**Ref: *Single Storey Extension to form a Bedroom - Bathroom and Games Room at
9 New Barn Lane North Bersted Bognor Regis West Sussex***

Arun District Council
Arun Civic-Centre
Maltravers Road
Littlehampton
West Sussex BN17 5LF
Planning & Building Control General
Enquiries
Tel: (01903) 737756 Fax: (01903) 716019
Dx: 57406 Littlehampton
Minicom: 01903 732765
e-mail: planning@arun.gov.uk
website: www.arun.gov.uk/planning
Our Ref: BE/17/11/
Your Ref:

Single storey extension & upgrading of existing garage to form an exercise room & bathroom
9 New Barn Lane North Bersted Bognor Regis

PART SUPERSEDED - PROPOSED SOUTH ELEVATION ONLY

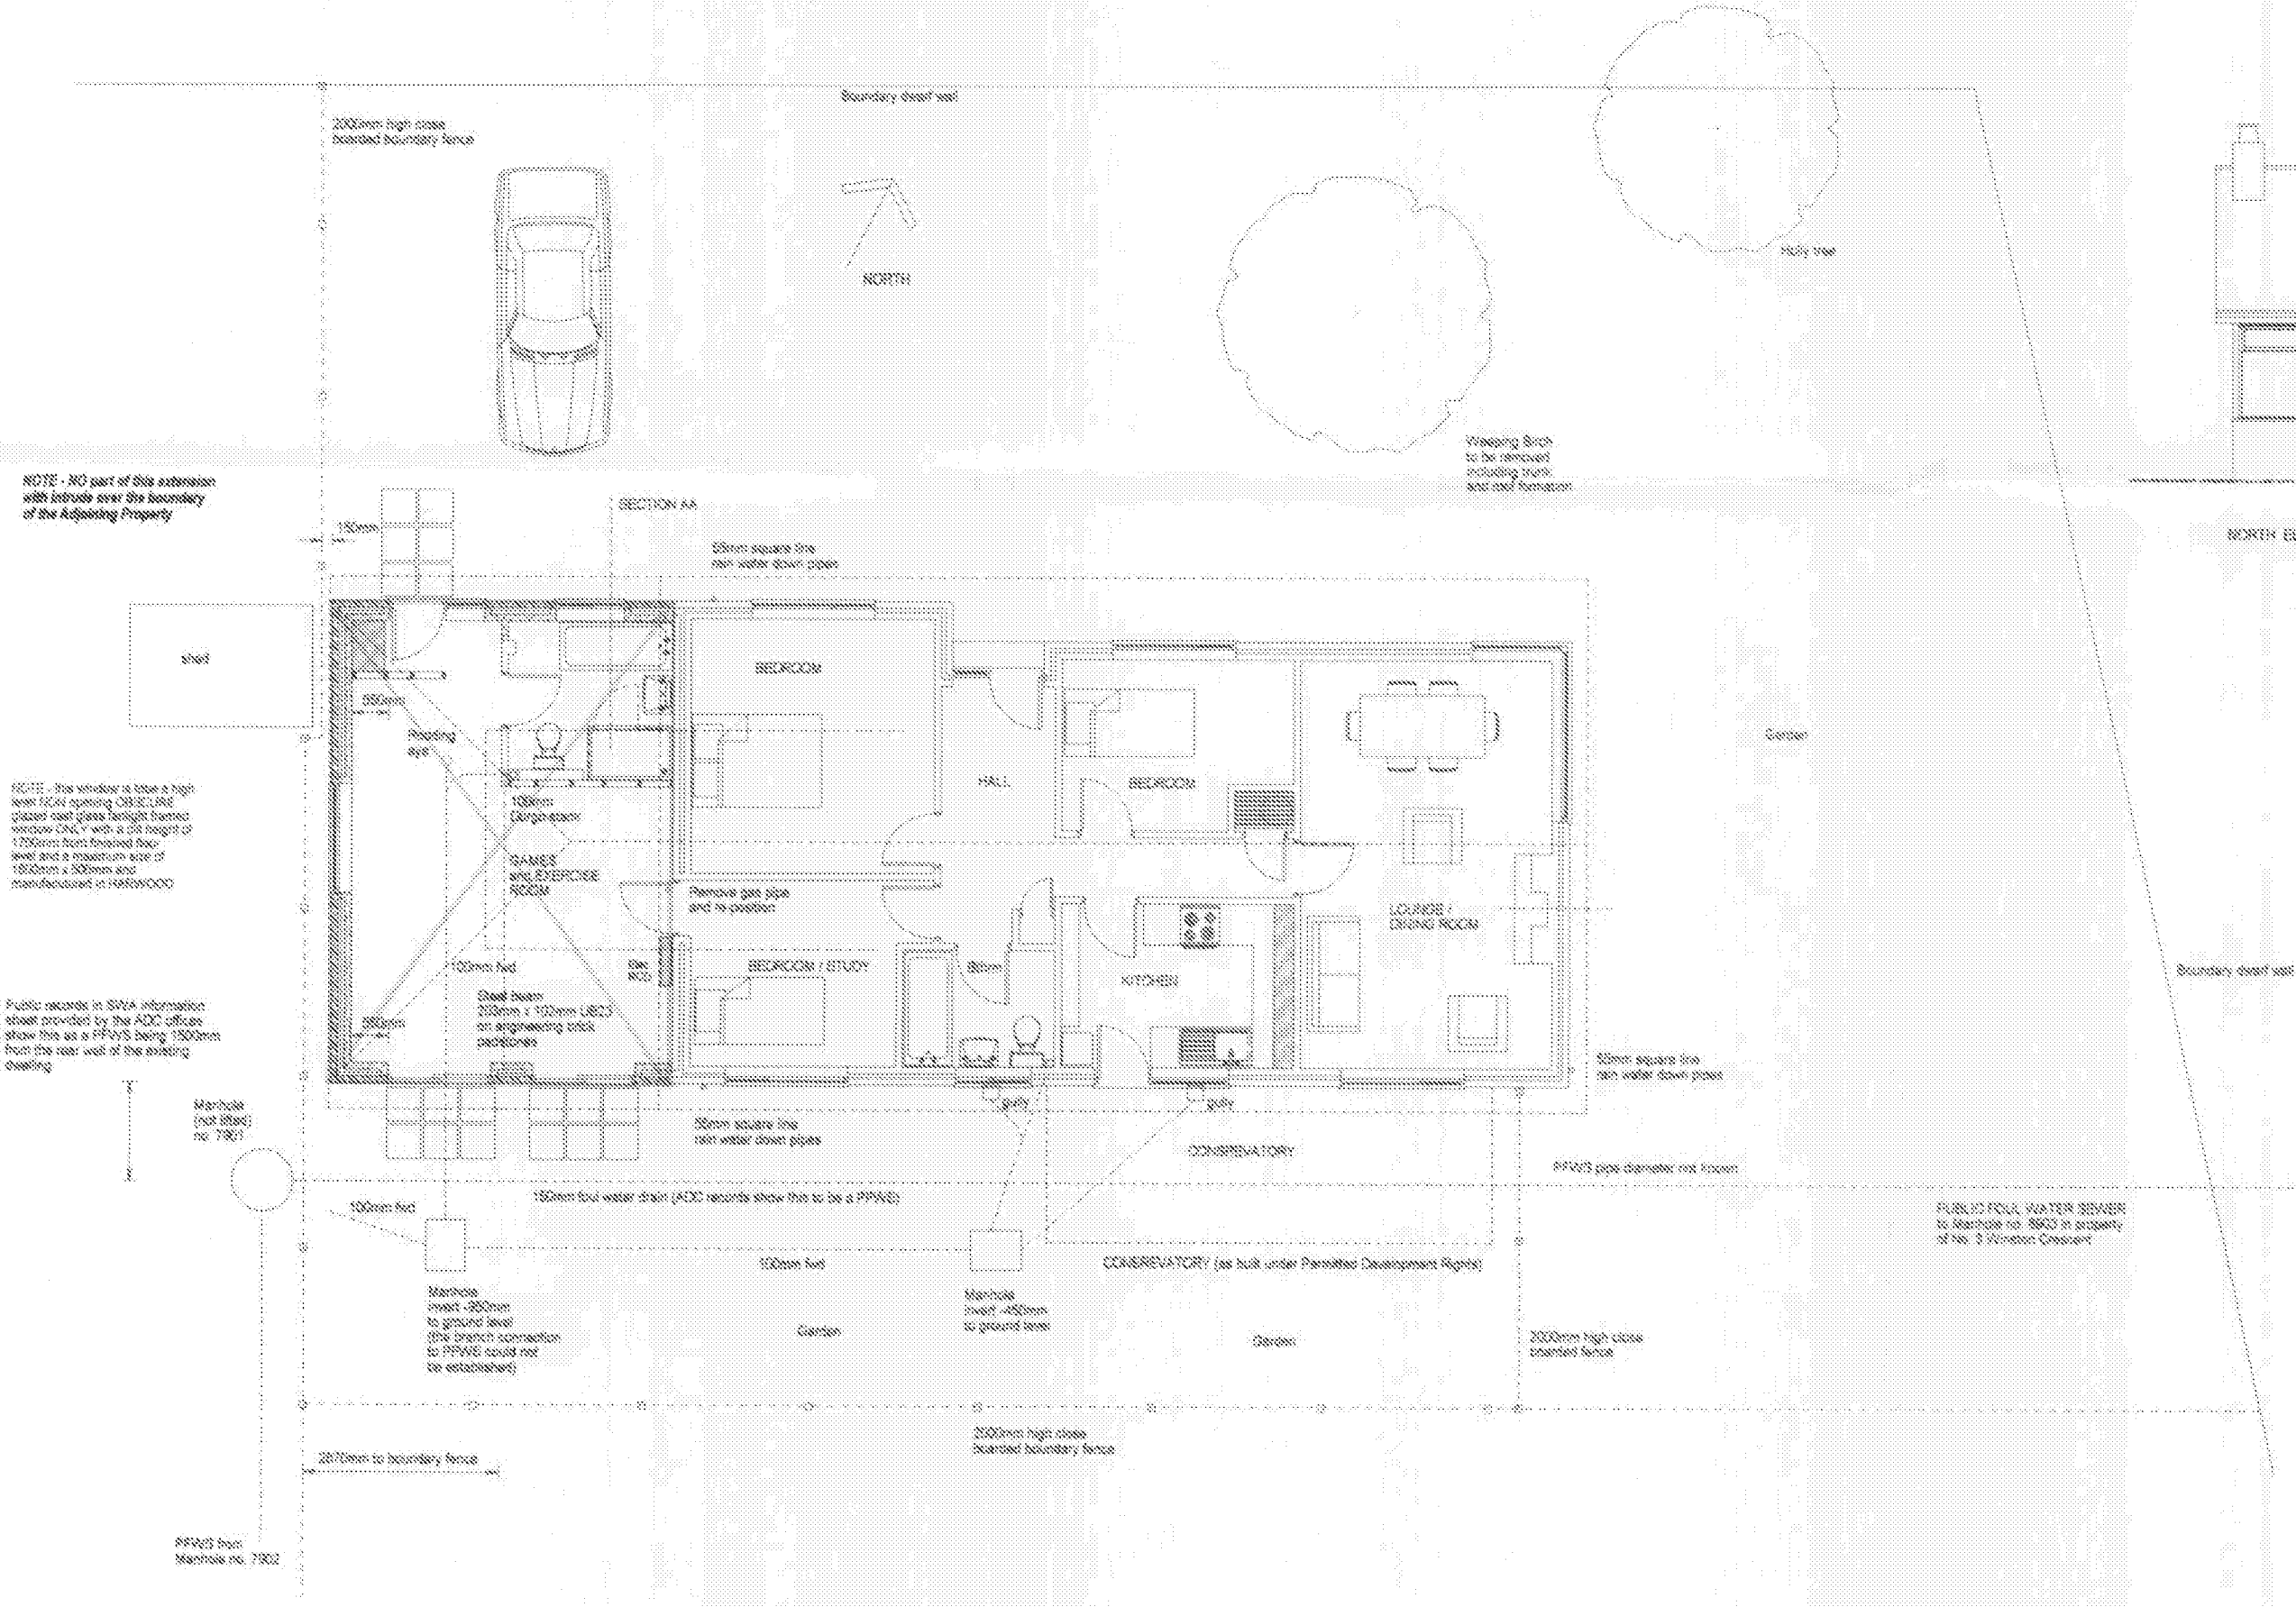
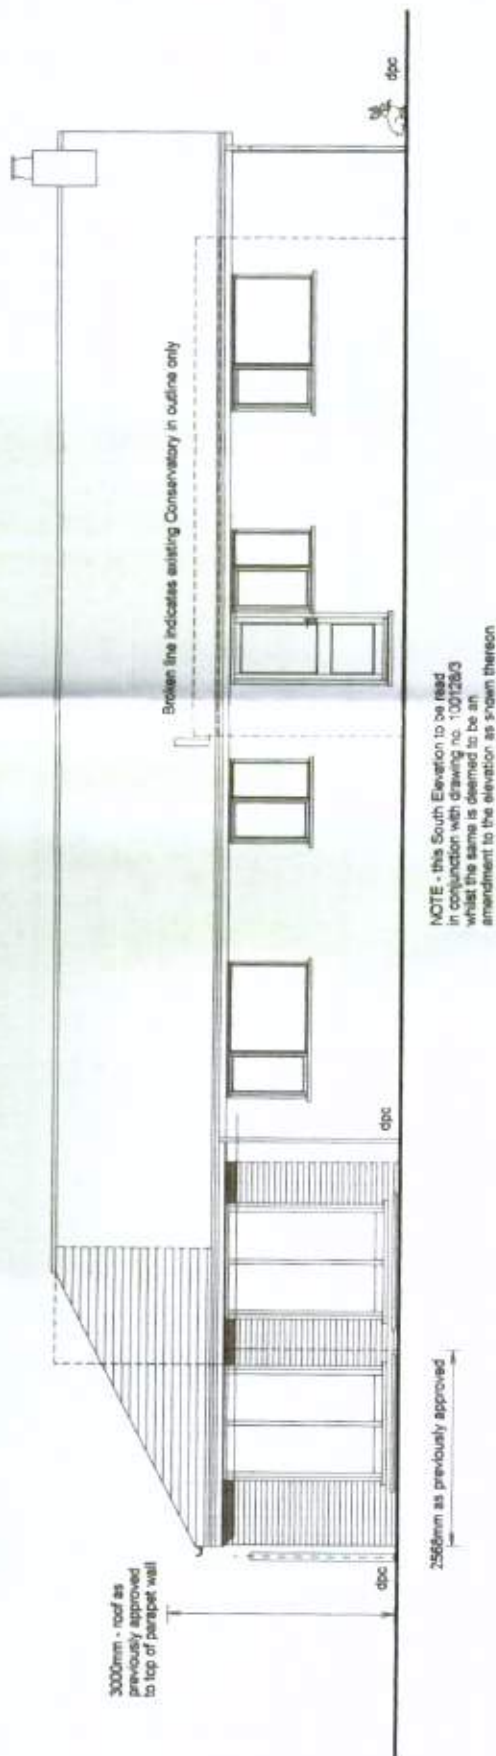
Please provide 1 electronic or 3 paper copies of a revised proposed south elevation. There is a window shown on the proposed floor plan which is not shown on the elevation.

CLIENT:	Mr Nettleton - 9 New Barn Lane North Bersted Bognor Regis	DESCRIPTION:	Site Block Plan (to replace that shown on 100129/1)
PROJECT:	Extension and Conversion to form Bedroom - Bathroom / Exercise Rm.	SCALE:	1:500
DATE:	February 2011	DRAWING No:	100129 11
		REVISION:

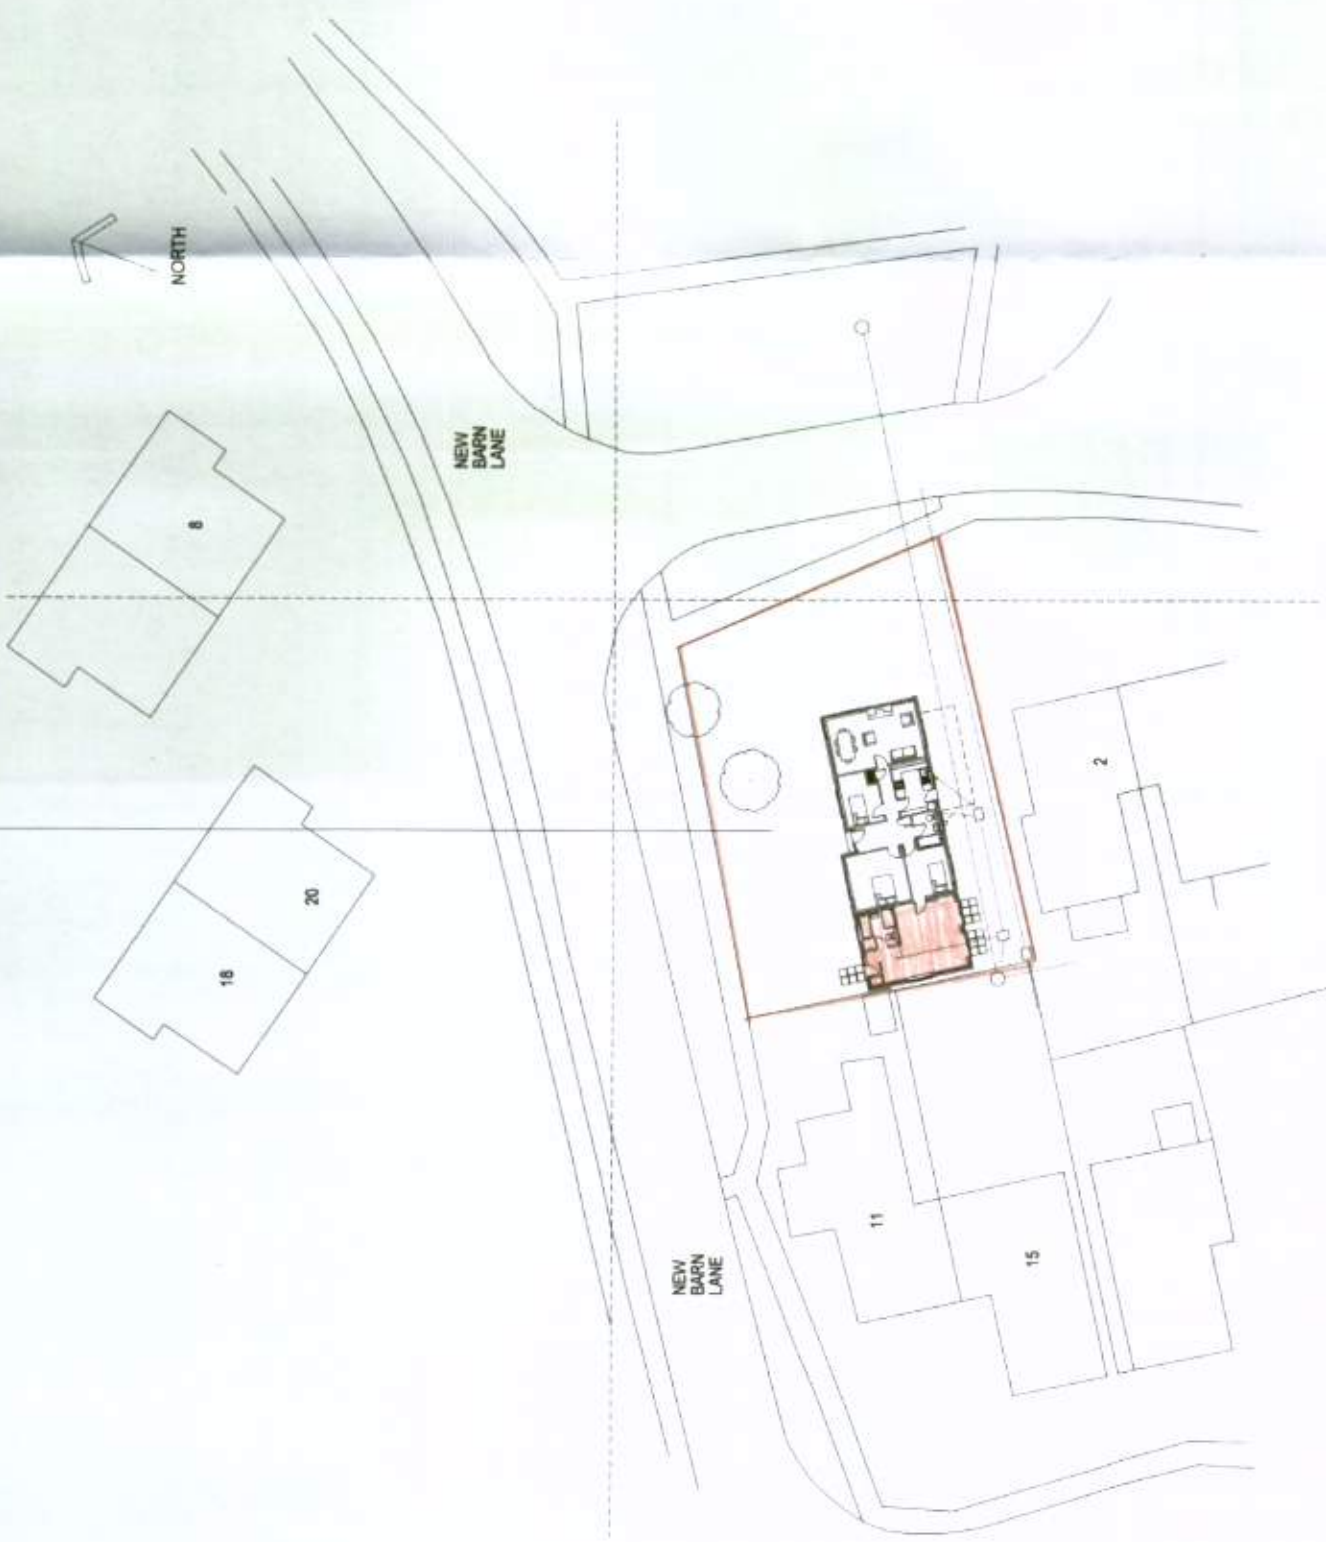
I require 1 electronic or 3 paper copies of a revised block/site plan showing the proposed works hatched/highlighted, in accordance with the guidance notes available on our website detailed below (click on National List).

In reply to your letter and the additional information requested I enclose 3 copies of site block plan highlighting the new works (NOT HATCHED as this is not described as such in your OWN Planning application Guidelines and you could not direct me to the word HATCHED in same only the word HIGHLIGHTED) together with 3 copies of the Location Plan with two named roads and coloured in red to show the site and lastly 3 copies of the South Elevation showing the window which was inadvertently omitted from same albeit shown on the floor plan - and would ask that you note that all this information is on A3 sheets which should be read in conjunction with the A2 copies lodged with you.
